Land at North West Bicester

Technical Note: Response to EA Drainage Comments: 20th April 2022

15th August 2022

Appendix A – Illustrative Surface Water Drainage Plan (10663-DR-01 D)

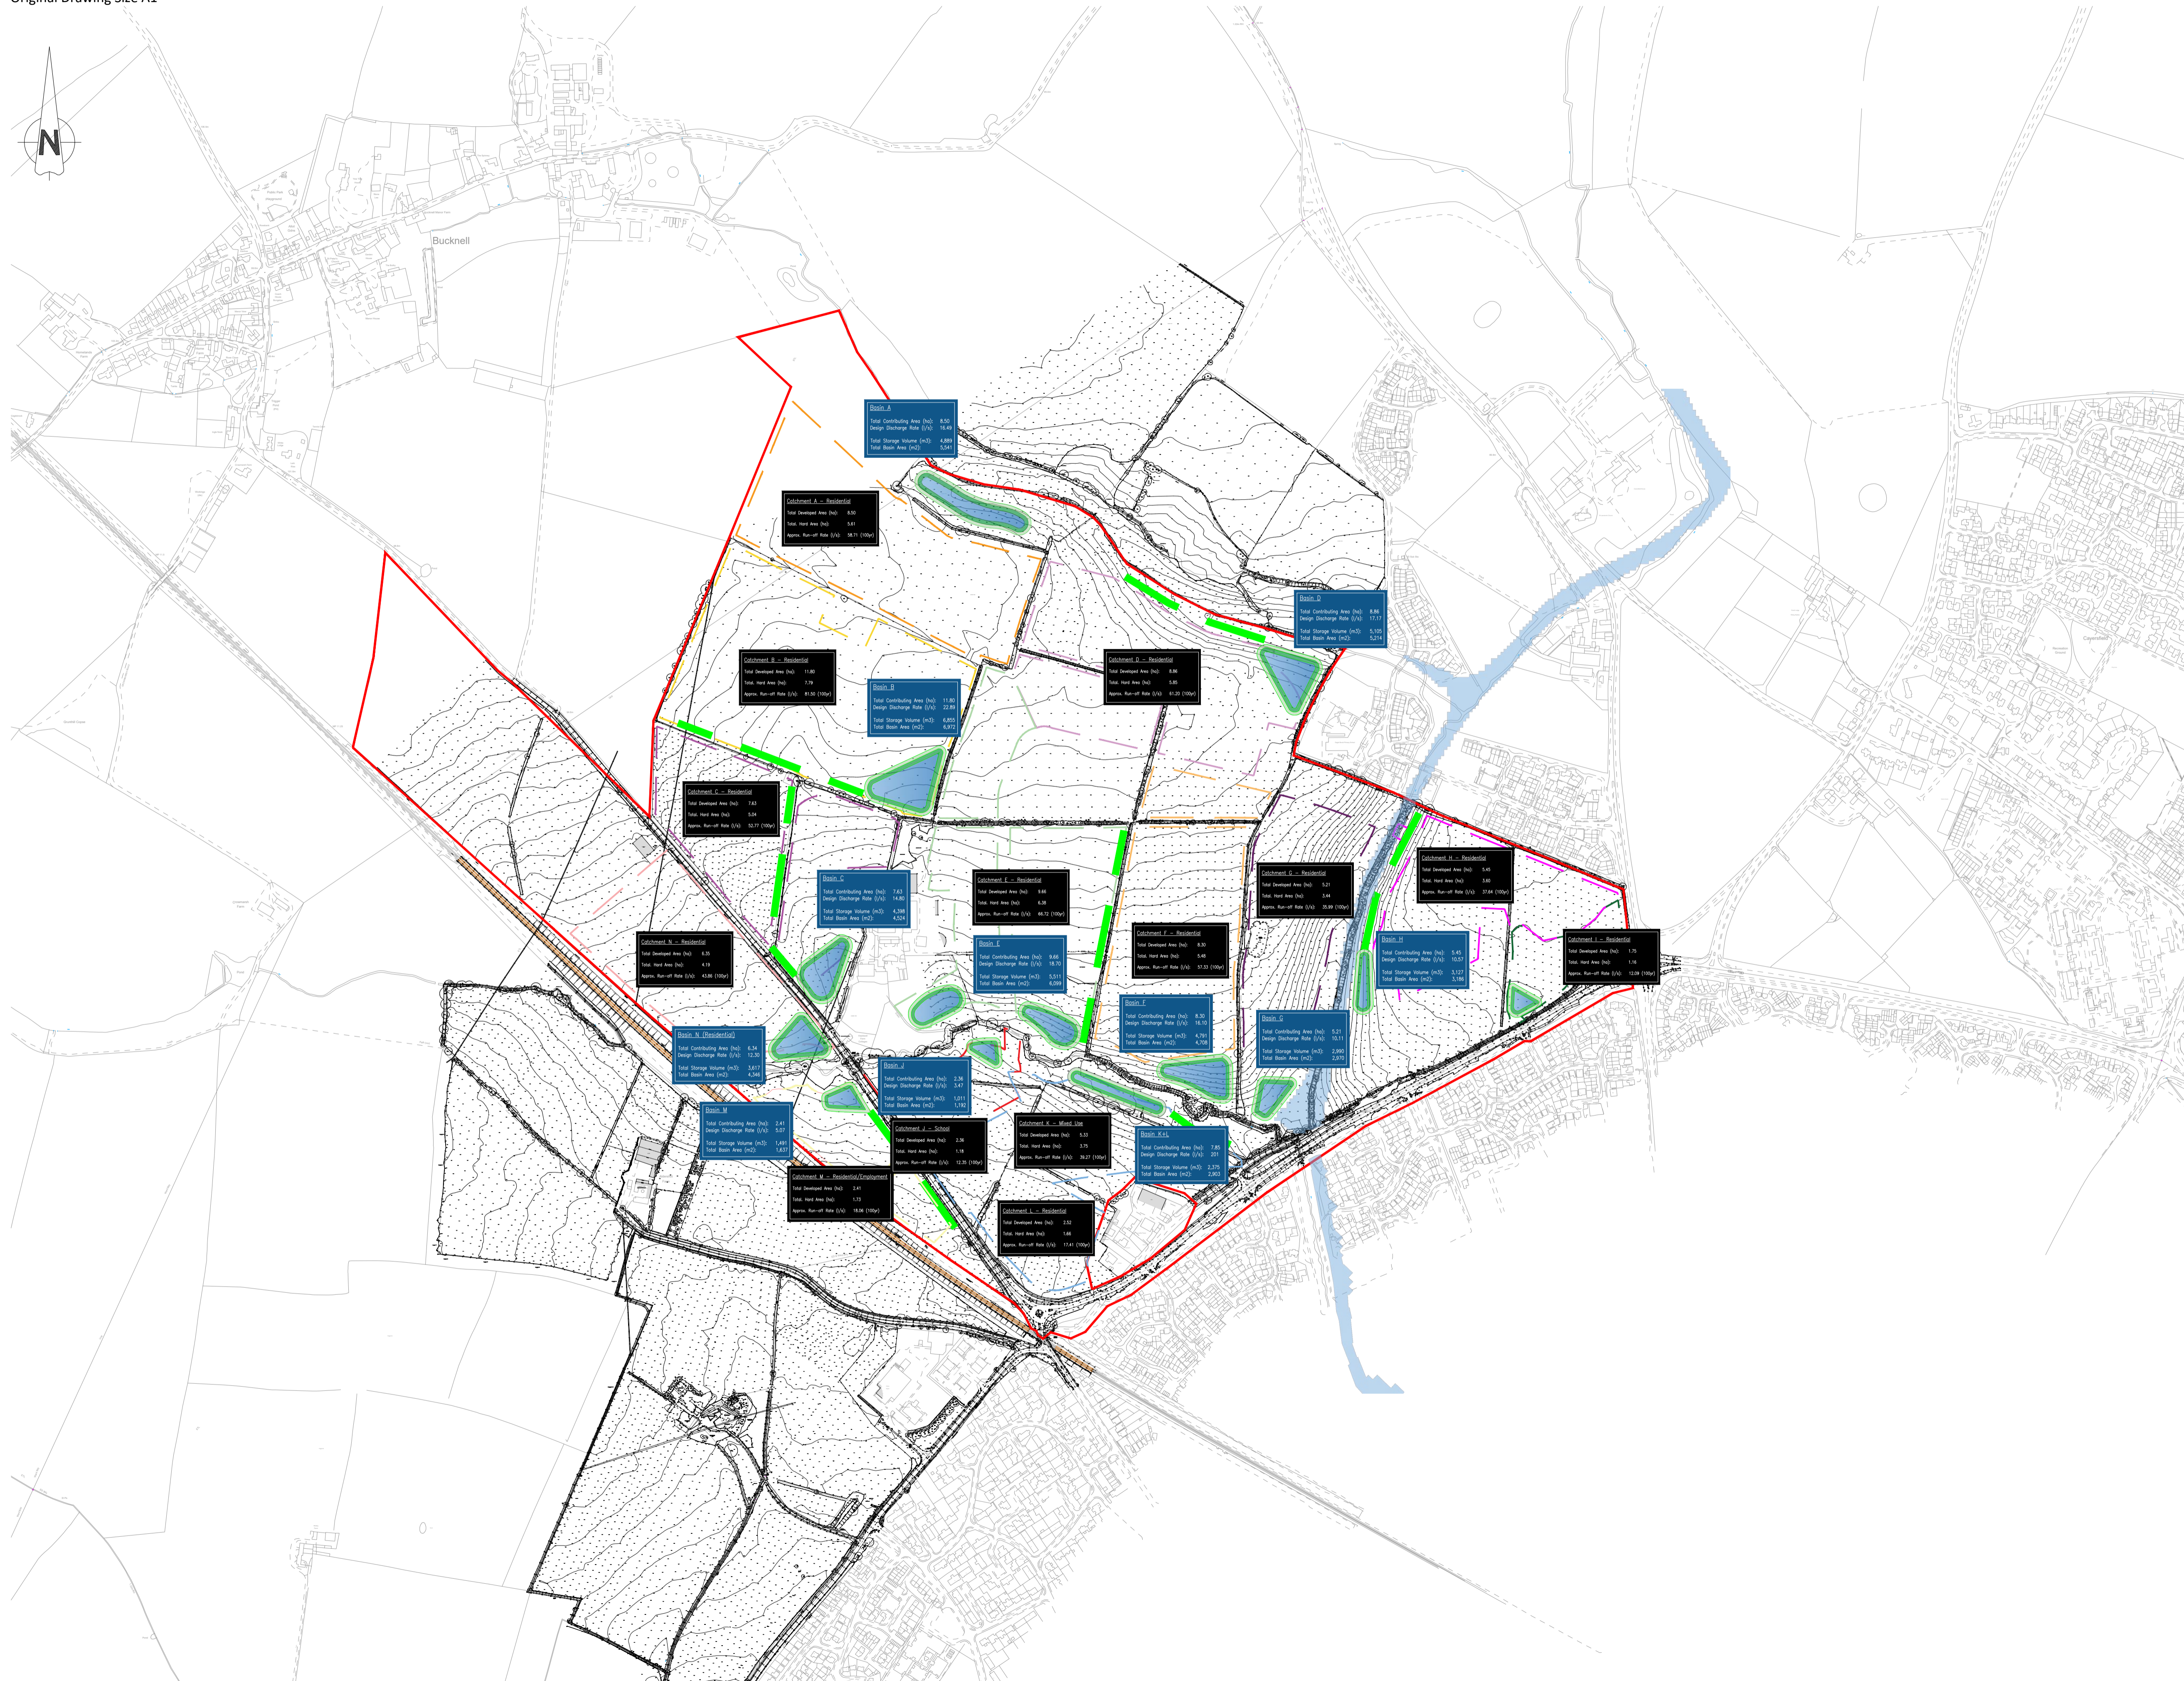
- 2.1 *In particular, the submitted FRA fails to demonstrate:*

1. *That an appropriate design flood level has been calculated for the site - i.e. the 1% annual probability flood level with an appropriate allowance for climate change (1% + climate change flood level).*
2. *That the proposed development has finished floor levels above the 1% Annual Exceedance Probability + climate change flood level.*
3. *The extent to which the proposed development impacts floodplain storage for the 1% annual probability flood event with an appropriate allowance for climate change (1% + climate change flood event).*

- 2.6 *For a development of this scale, we would expect you to carry out detailed flood modelling to calculate an appropriate design flood level - i.e. the 1% annual probability flood level with an appropriate allowance for climate change (1% + climate change flood level).*

- 2.2 All built development is located within the current flood zone 1, as defined by the latest Environment Agency mapping, and is therefore outside any risk of flooding. There are areas of flood zones 2 and 3 as illustrated on Figure 6-1 of the Flood Risk Assessment and on the drainage strategy plan (10663-DR-01 F). Figure 2-1 of this note illustrates the existing flood extents against the proposed development parcels.

- 2.3 To further reduce the risk of future flooding, all development is located at a minimum of 25m back from the edge of any watercourse bank.

- 2.4 With all development in flood zone 1, finished floor levels will be above the 1% annual probability flood event with climate change.

- 2.5 As all development is located within flood zone 1, there is no development proposed within the active floodplain of the onsite watercourses.

- 2.7 The parameters presented at this outline planning stage clearly show all built development within the site is located within flood zone 1 and set back from any onsite watercourses that could pose a risk of fluvial flooding. This allows for a development that can be built in accordance with NPPF and Table 3: flood risk vulnerability
